Addendum No. 2

RE: Contract # C204741

Cabarrus County (B-5808)

BRIDGES #57 AND #59 OVER IRISH BUFFALO CREEK ON US-29 AND US-601.

STATE OF NORTH CAROLINA DEPARTMENT OF TRANSPORTATION RALEIGH			
TYPICAL SECTION STAGE 2			
REVISIONS			
NO.	BY:	DATE:	SHEET NO.
1			S-9
2			TOTAL SHEETS 65

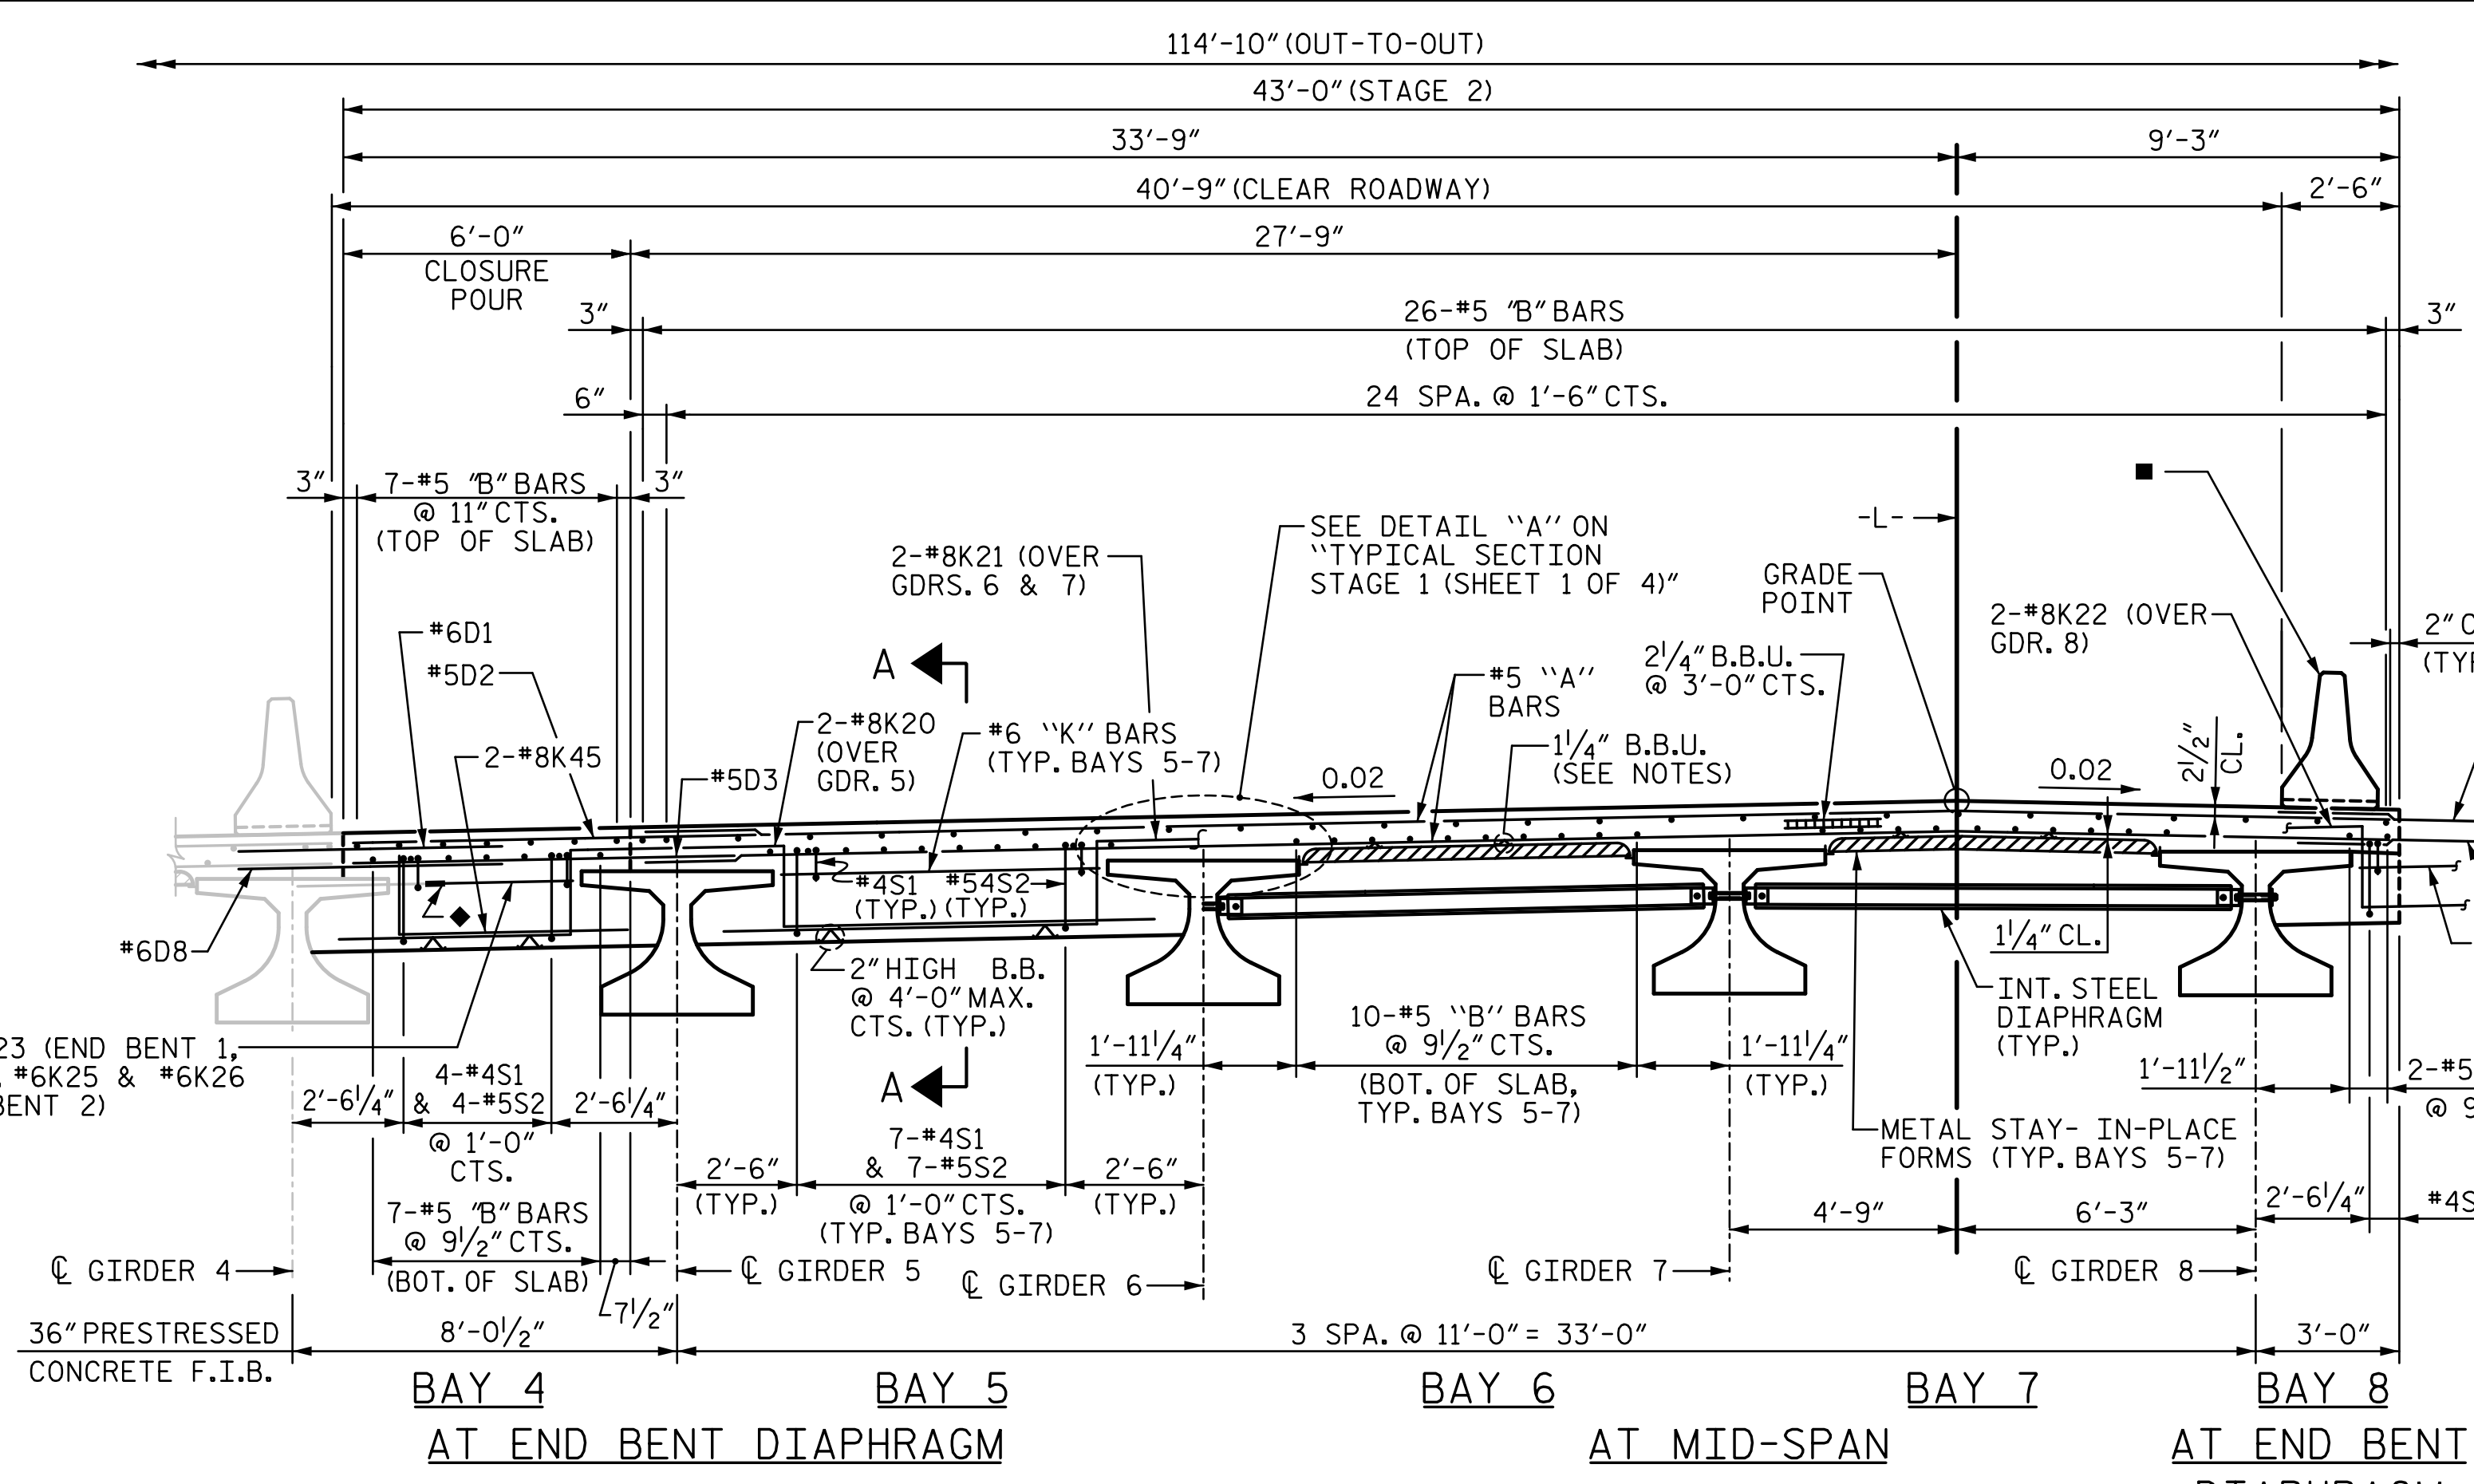
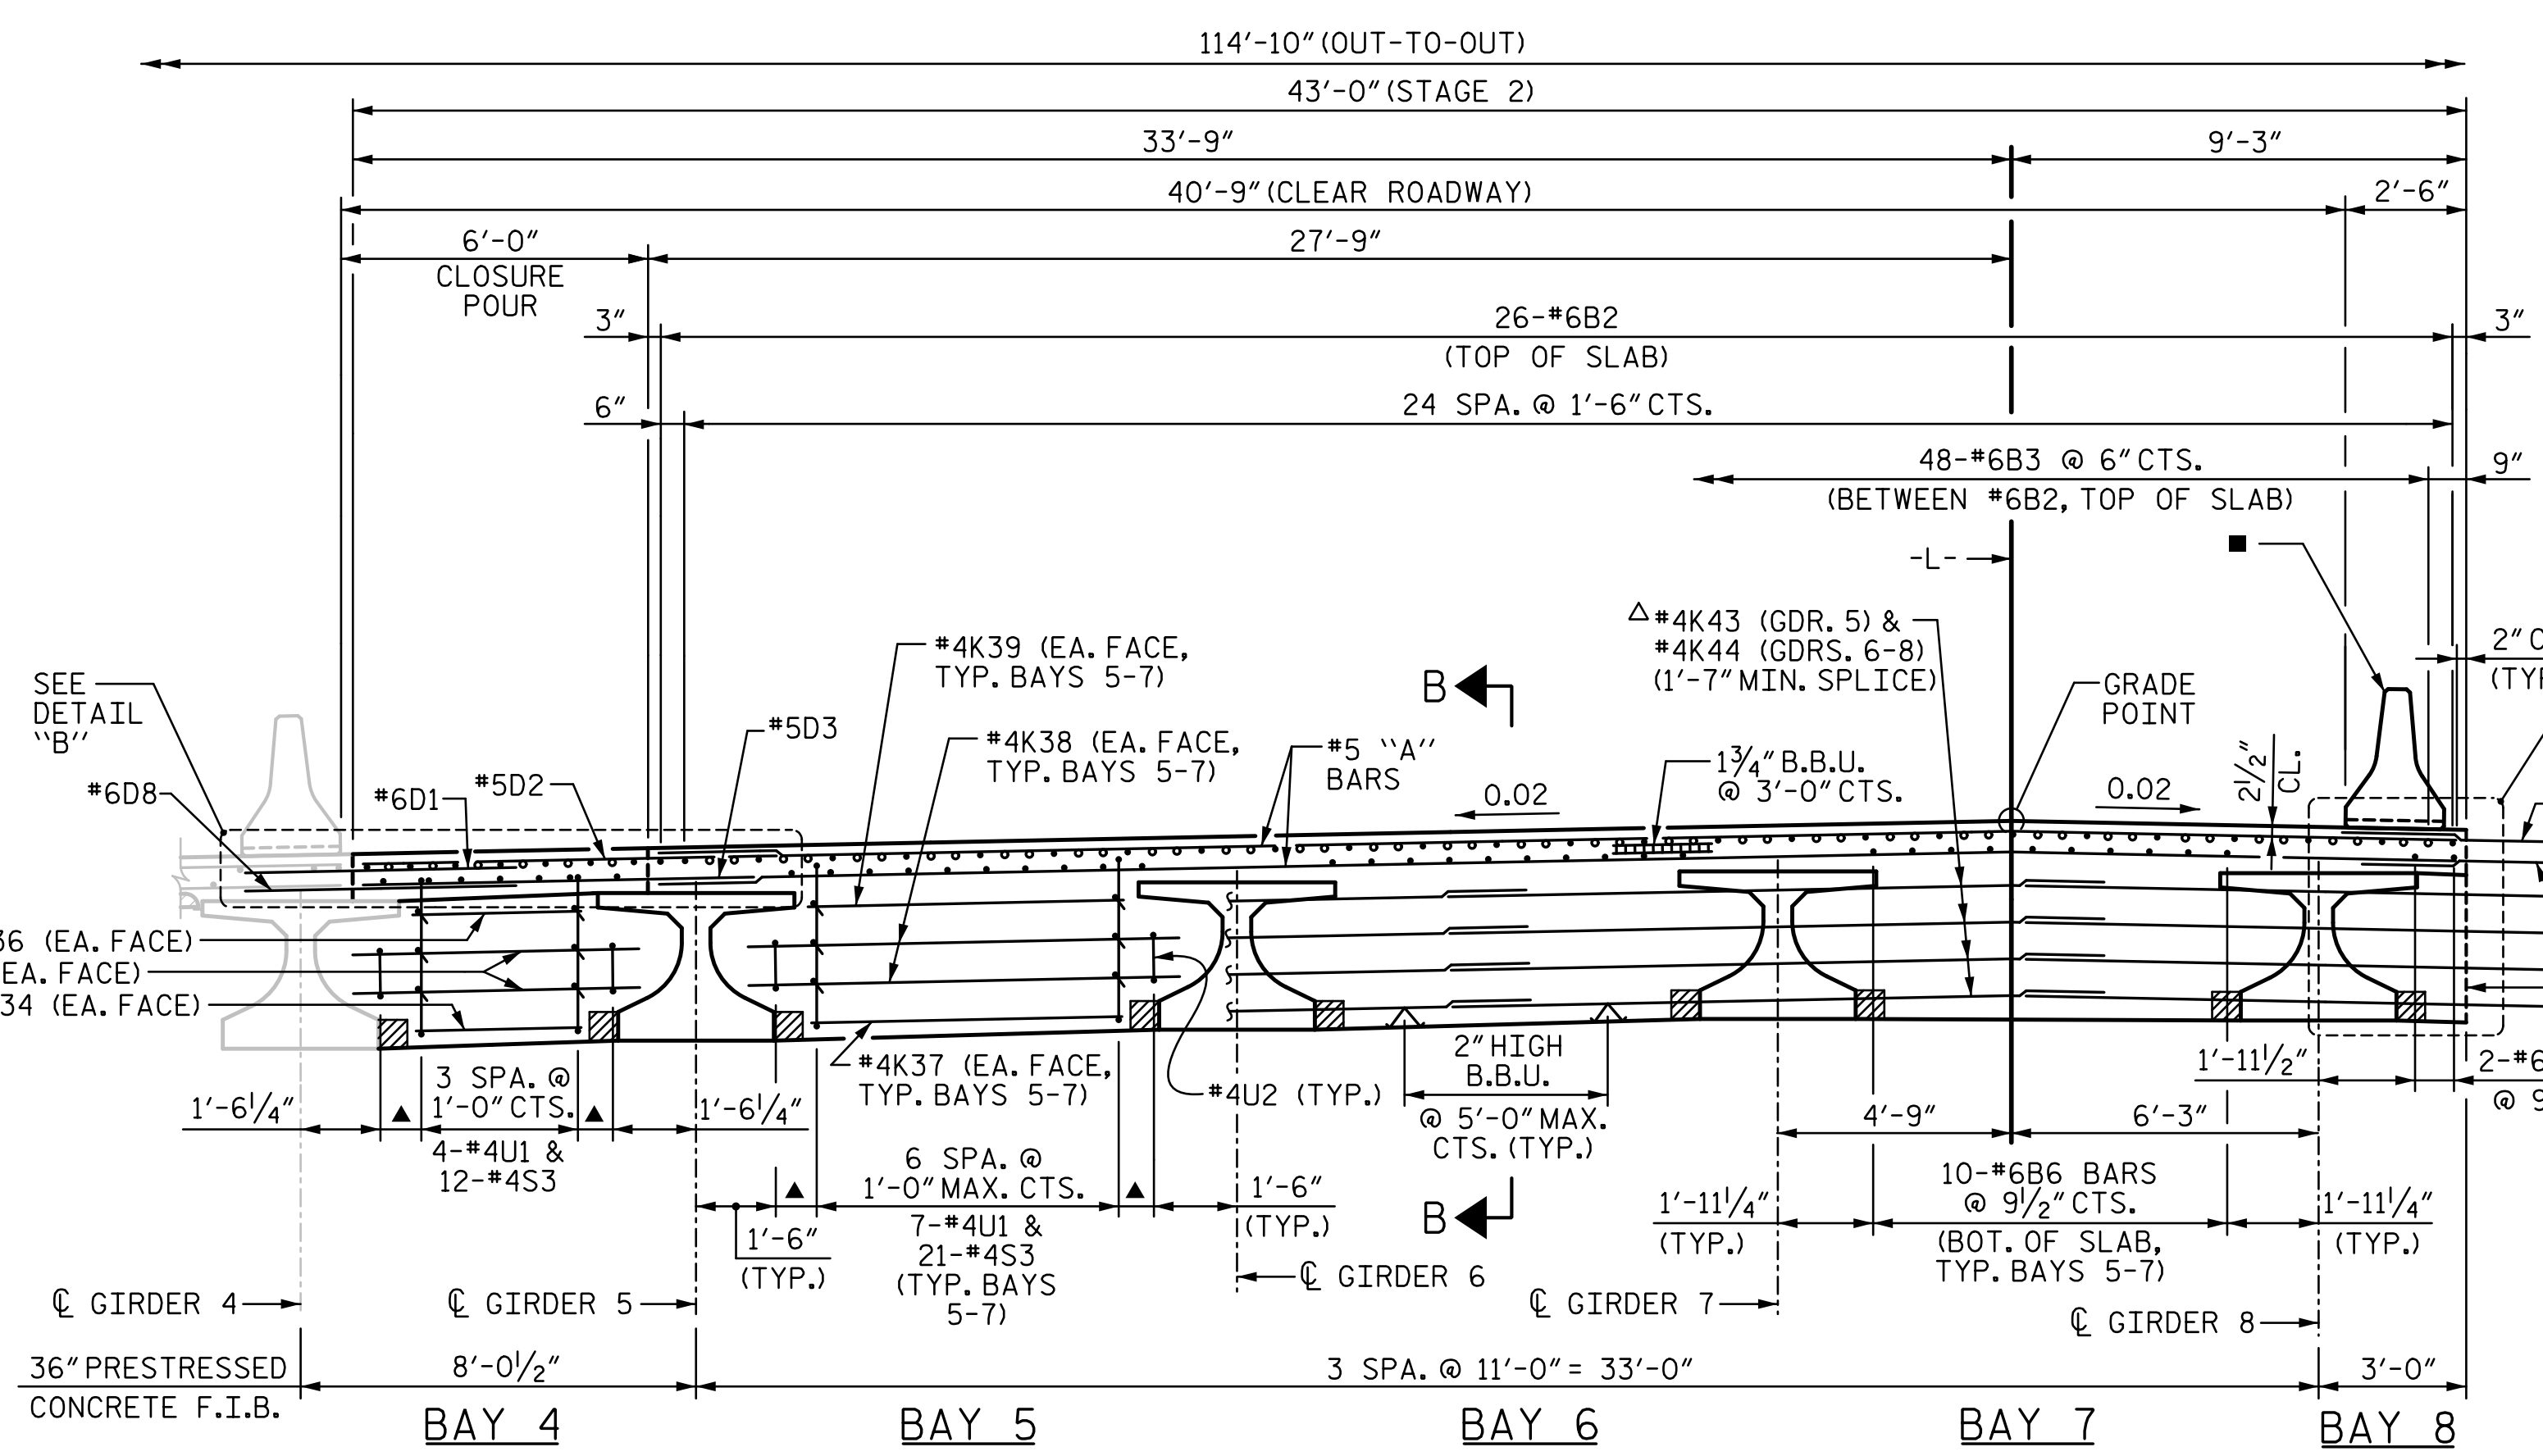
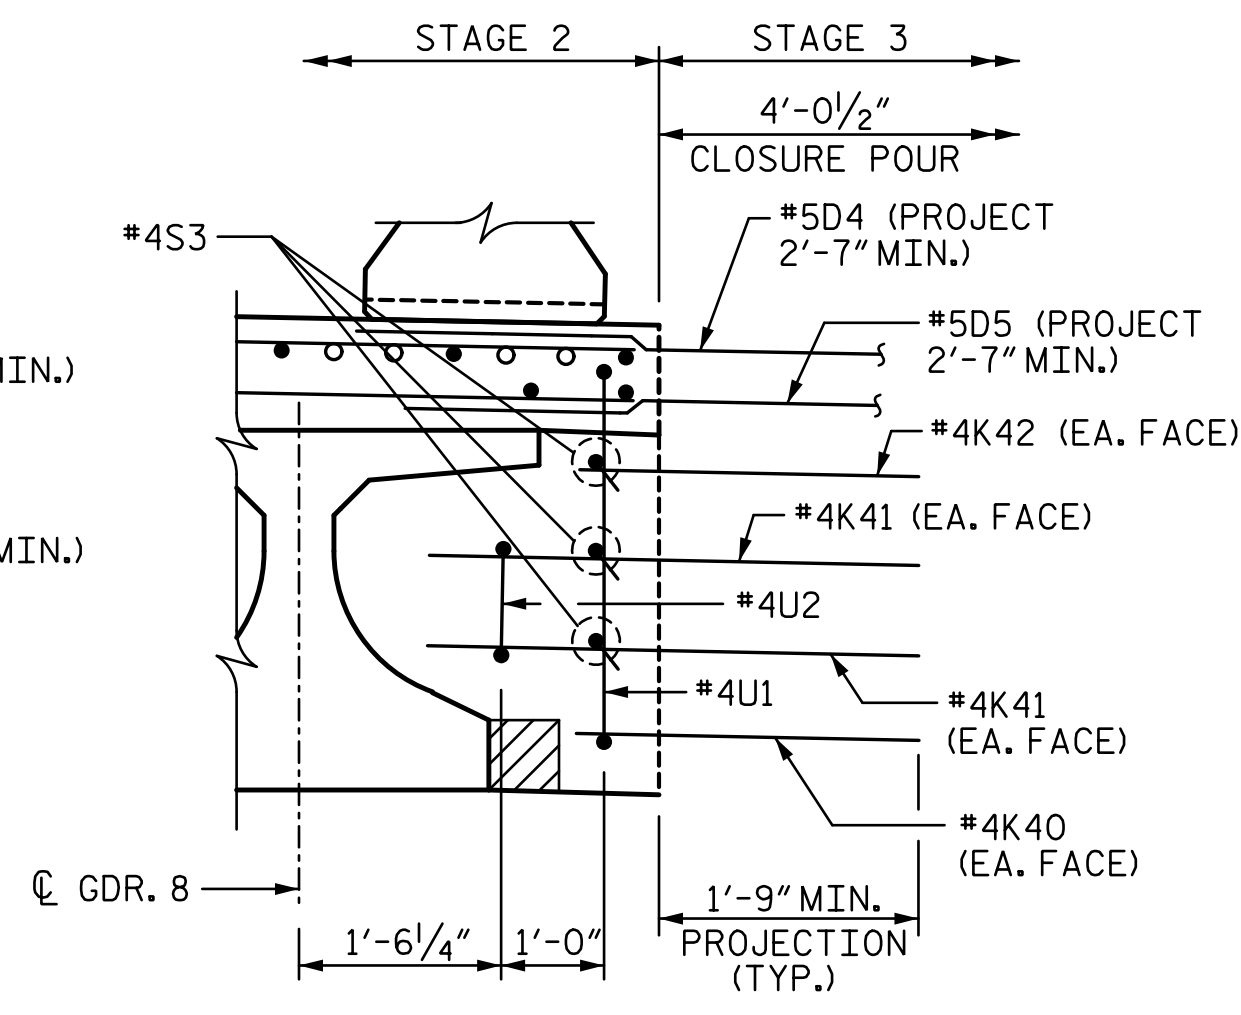
Sheet No.	Revision
S-6 thru S-8	Note regarding Temporary Barrier added.
S-9	Temporary Barrier w/Drainage Slots note revised.
S-25	Twelfth Paragraph removed under "Notes".
